DELEGATED HOUSEHOLDER DECISION

Item No.	Report of the Head of Development Management and Building Control		
Address:	123 CHARVILLE LANE HAYES		
Development:	Conversion of roof space to habitable use including erection of 6 no. dormers and erection of a single storey rear extension with habitable roof space. Fenestration changes to rear and side elevations (amended drawings)		
LBH Ref Nos:	8692/APP/2023/2858		
Drawing Nos:	Location Plan PL/01 PL/02 Rev C PL/03 Rev D PL/04 Rev D		
Date Plans received:	29-09-23	Date(s) of Amendments(s):	12-01-24
			12-01-24
Date Application valid	29-09-23		12-01-24

PROPOSED ROOF PLAN
1:100 @A3

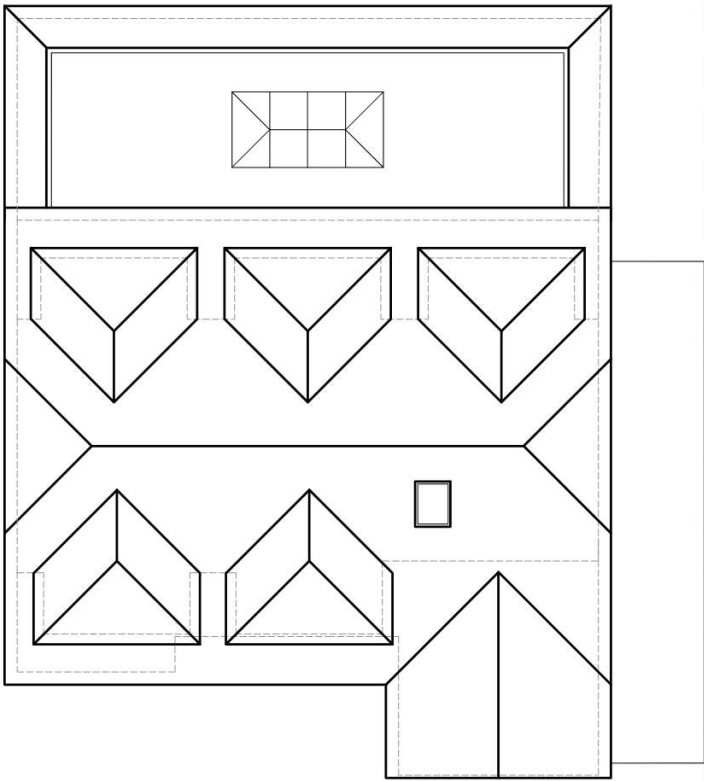
Throughout the process of the application, revised drawings have been sought requesting the dormer extensions to be reduced in number and size. The revised drawings show 1 large front dormer, 1 large rear dormer, 2 right side dormers and 2 left side dormers. Due to the excessive number and size of the proposed dormer extensions, it is considered that they would cause a top heavy, disproportionate and cluttered addition that would over dominate the original bungalow. The development could not be built under permitted development. Dormer extensions are seen within the immediate surrounding area, however these are proportionate to the size of the dwellings and do not appear incongruous. As such, the proposed additions would cause significant harm to the character and appearance of the original dwelling and street scene.

The dividing wall of the bedrooms within the loft intersects the front and rear dormer windows, presenting an undesirable relationship to the appearance of the fenestration when viewed from the street.

Due to the cumulative number, size, bulk and massing of the dormer extensions, the proposed development would appear as an incongruous addition failing to respect the original roof form and architectural composition of the dwelling. The positioning of the dividing wall within the loft bedrooms also intersects the dormer windows, which is considered to be poor design.

PROPOSED FIRST FLOOR PLAN
1:100 @A3

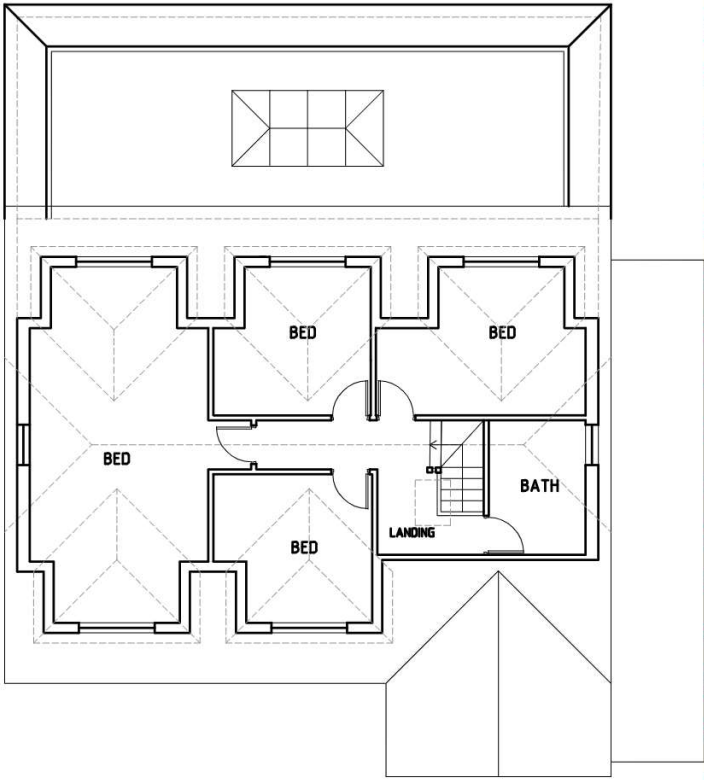
The proposed front and rear bedrooms at first floor level would only be served by one front and one rear dormer which share a window. The level of light and outlook would be shared with one window with a surface area of approx. 1.26m².

The first floor bedrooms are also narrow which would exacerbate the issue further as it would be hard for light to penetrate the rear of the rooms. It is therefore considered that there would be an unacceptable level of light and outlook to the first floor bedrooms causing unacceptable living conditions for current and future occupiers, contrary to Policy DMHB 16 of the Hillingdon Local Plan: Part 2 - Development Management Policies (2020) and Policy D6 of the London Plan 2021.

The proposed first floor front and rear bedrooms would have an insufficient level of light, ventilation and outlook due to the shared windows within the front and rear dormer extensions. Consequently, the proposal would impact the living conditions of current and future occupiers of the dwelling adversely, contrary to Policy DMHB 16 of the Hillingdon Local Plan: Part Two - Development Management Policies (2020) and Policy D6 of the London Plan (2021).
